Item No. **Report of the Head of Development Management and Building Control**

Address: 12 HIGH STREET HAREFIELD

Development: Erection of a single storey extension to rear (Retrospective application)

LBH Ref Nos: 11022/APP/2024/1282

Existing Ground Floor Plan

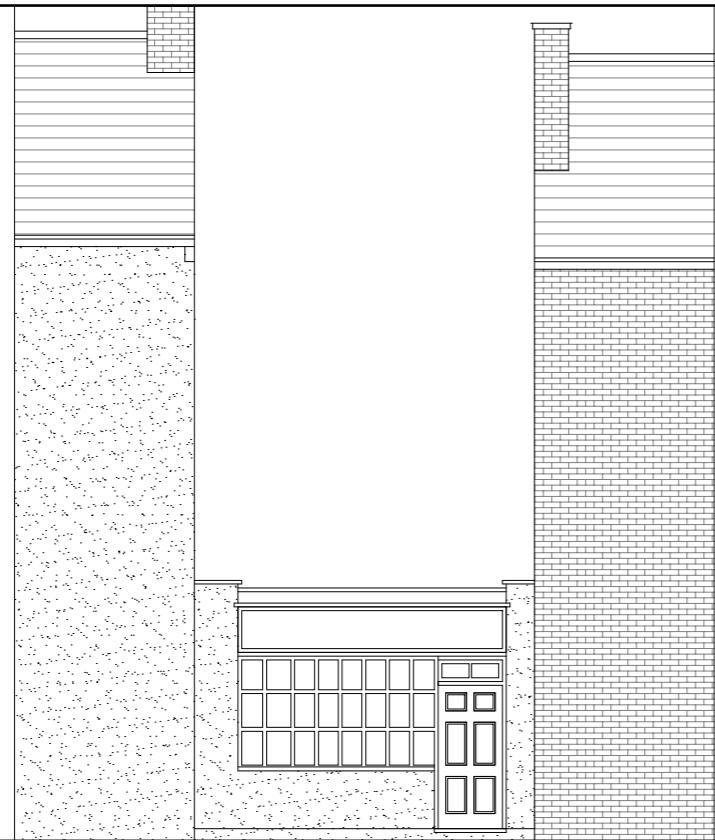
The proposal consist of a single storey rear extension which measures approx 7.4m deep with a flat roof max height 2.7m high.

The application seeks retrospective consent for a single storey rear extension which measures approx 7.4m deep with a flat roof max height 2.7m high. The application is located within the conservation area adjacent to a Grade II listed building and has no heritage statement, contrary to the government advice set out in the framework. The Conservation Officer has raised objections to the extension as it is substantial with no justification provided. In addition, the scale, design and use of poor quality materials are not in keeping with the character of the conservation area and no other building has extended to such a depth, which would set an unfavourable precedent. There are no

similar sized extensions within the immediate area and given its proximity to the Grade II Listed Building and its conservation area, it would fail to enhance and also detract of the local character.

Existing Elevations

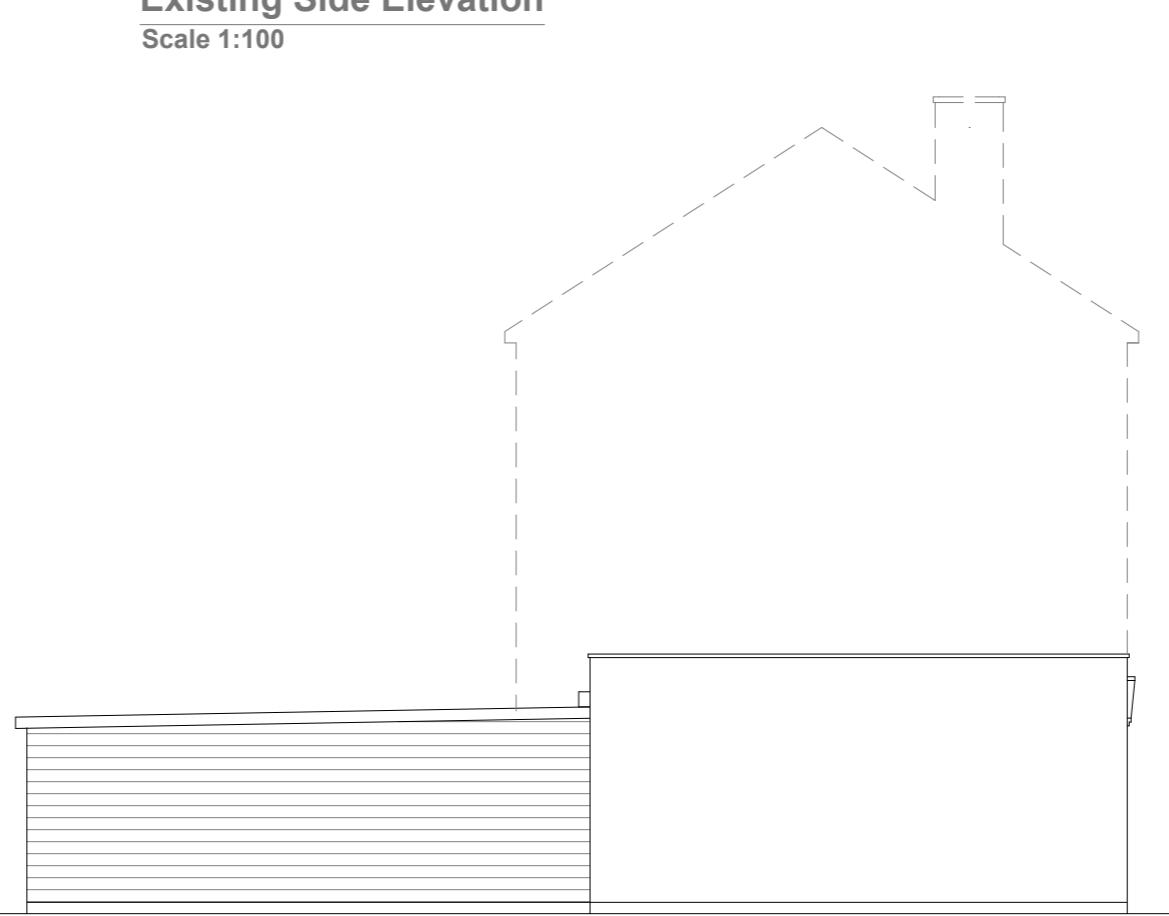
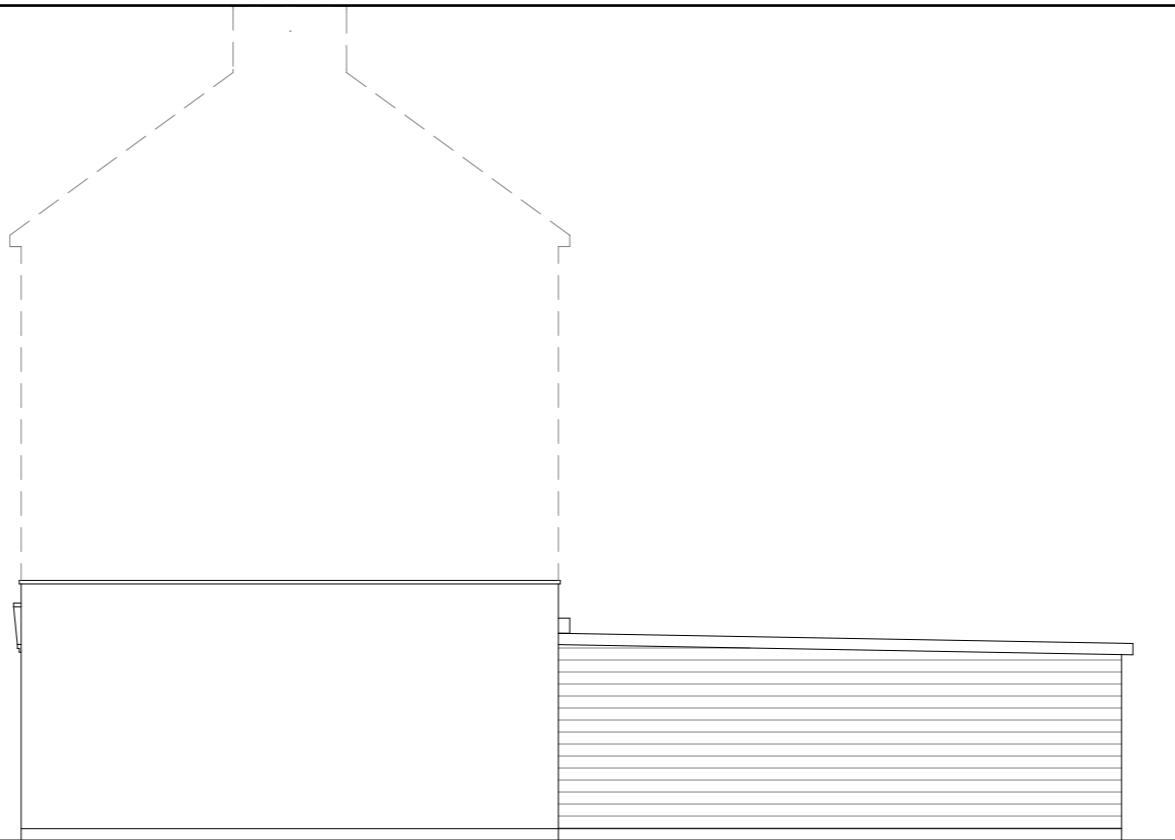
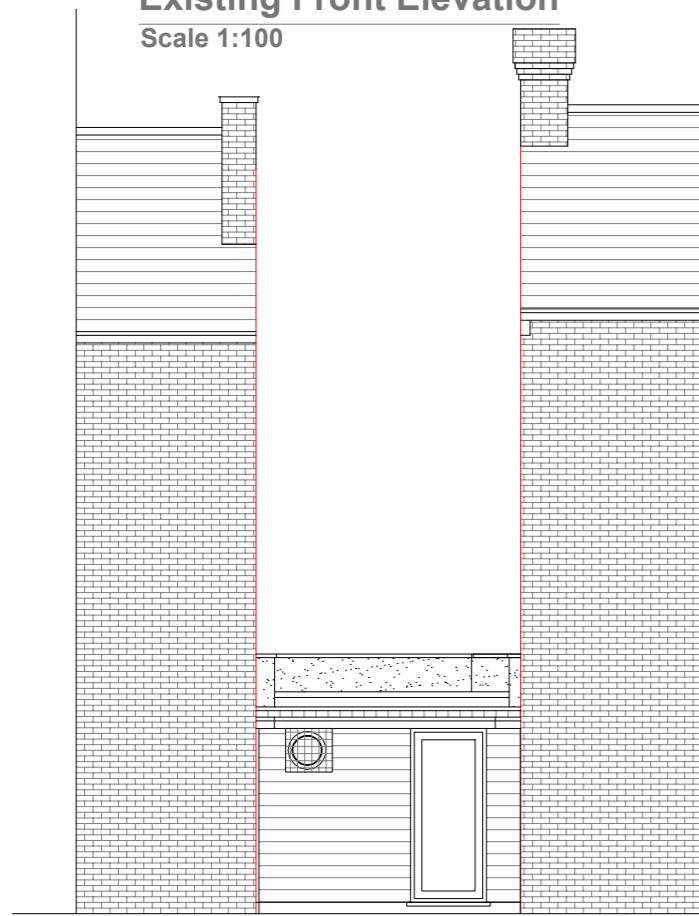
The single storey rear extension, by reason of excessive scale, design, bulk, siting and poor quality materials would result in unacceptable harm to the architectural composition of the building and is detrimental to the character and visual amenity of the area and fails to preserve or enhance the character and appearance of the Harefield Village Conservation Area and the setting of the adjoining Grade II Listed building. The proposal would therefore conflict with National Planning Policy Framework (2023), Policies D3 and D4 of the London Plan (2021), Policies HE1 and BE1 of the Hillingdon Local Plan: Part One Strategic Policies (2012) and Policies DMHB 1, DMHB 2, DMHB 4, DMHB 11, DMHB 12 and DMHD 1 of the Hillingdon Local Plan: Part Two - Development Management Policies (2020).

conservation area adjacent to a listed building and has no heritage statement. This is contrary to the government advice set out in the framework. We would object and recommend refusal. The proposal has a substantial extension to the rear with no justification provided. Its scale and design is not in keeping with the character of the conservation area and as such should be refused as it is contrary to policy and guidance due to causing harm to the designated heritage asset. We would also object to the new shopfront which has not yet been applied for. It is most out of keeping with the character of the area with garish inappropriate colours, lack of detailing and not appropriate for the conservation area. As such we believe that it causes harm both to the designated conservation area and the heritage asset of the adjacent listed building. There has been no public benefits put forward to outweigh this harm. As such it is contrary to local and national policy. Therefore we would object and recommend refusal.
